April 25, 2019 File: PE4060-LET.03

Subject: Response to Site Plan Comments City File No. D07-12-17-0172 Re: Phase I ESA and Phase II ESA 444 Bronson Avenue Ottawa, Ontario

TC UNITED	
PHASE II - ENVIRONMENTAL SITE ASSESSMENT	
444 BRONSON AVENUE	
OTTAWA,	ONTARIO
Title: TEST HOLE LOCATION PLAN

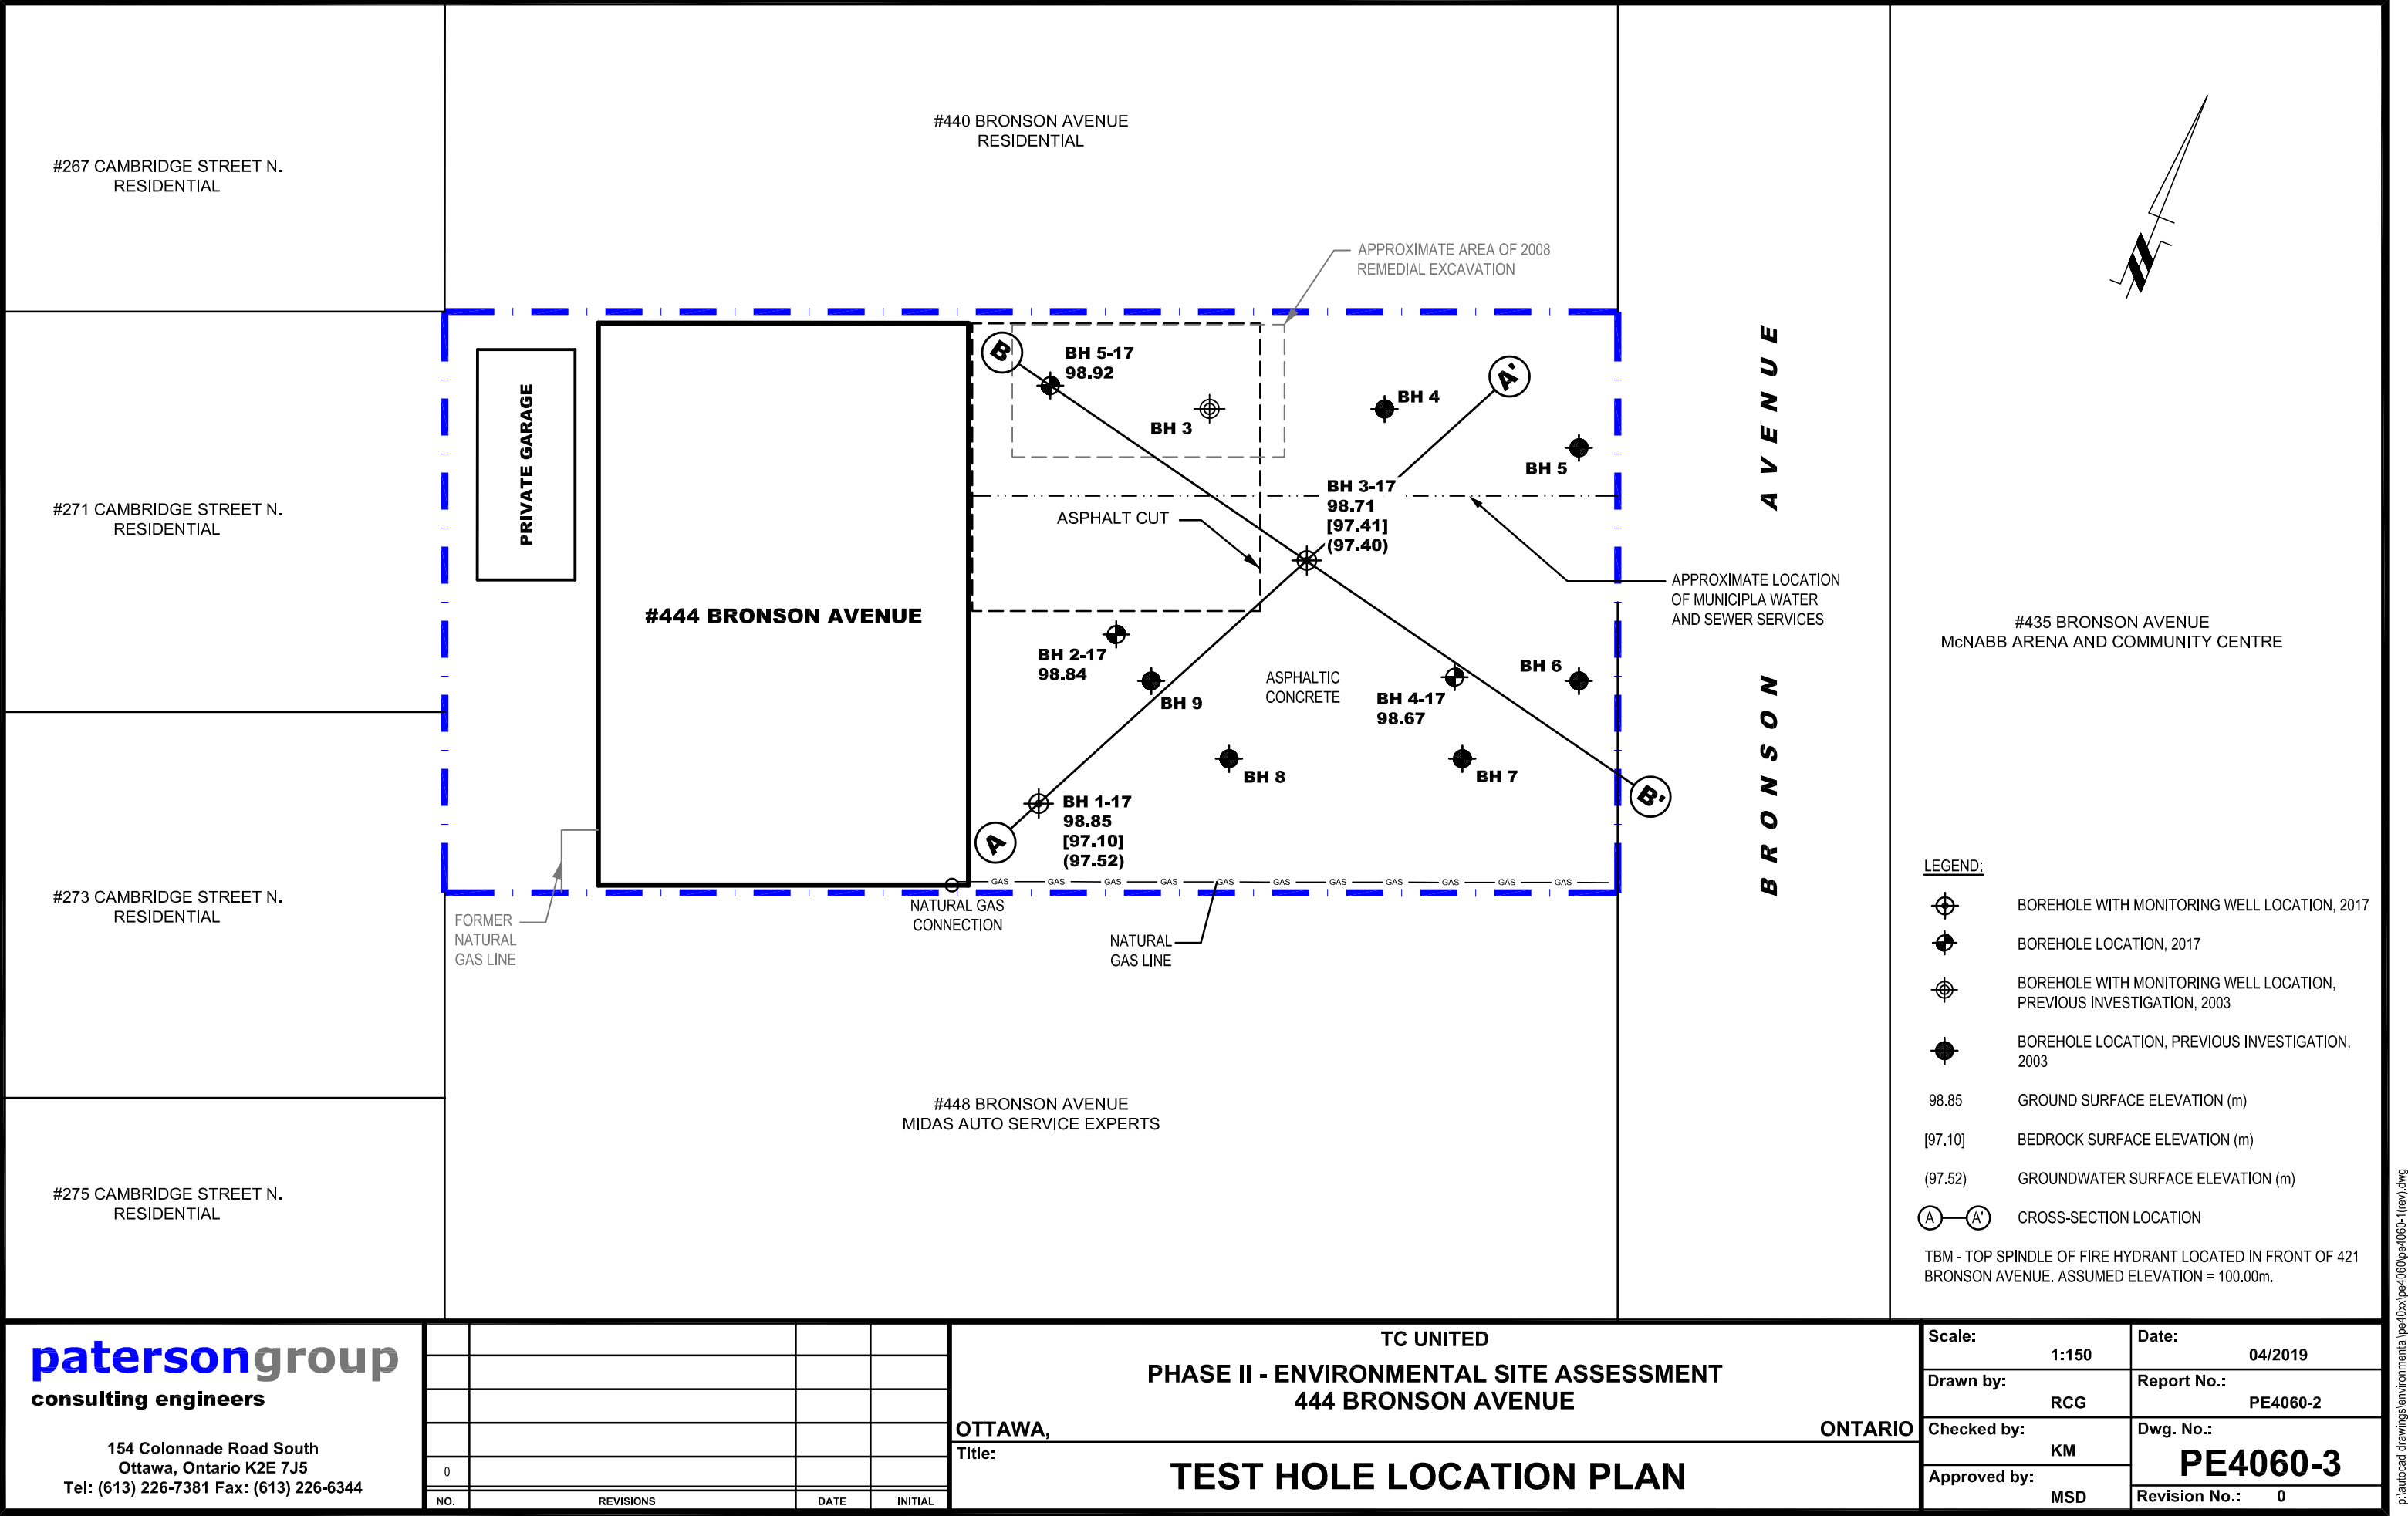
2. Additional boreholes will be required at boundaries of the property to ensure contamination has not infiltrated neighbouring properties.

Based on the findings of the Phase II ESA, the groundwater is considered to be present within the bedrock and is in compliance with the MECP Table 7 standards. Based on this information in combination with the fact that the site is covered with asphaltic concrete or a building structure limiting effects of leaching, the potential for off-site migration of impacts within the overburden is considered to be negligible.
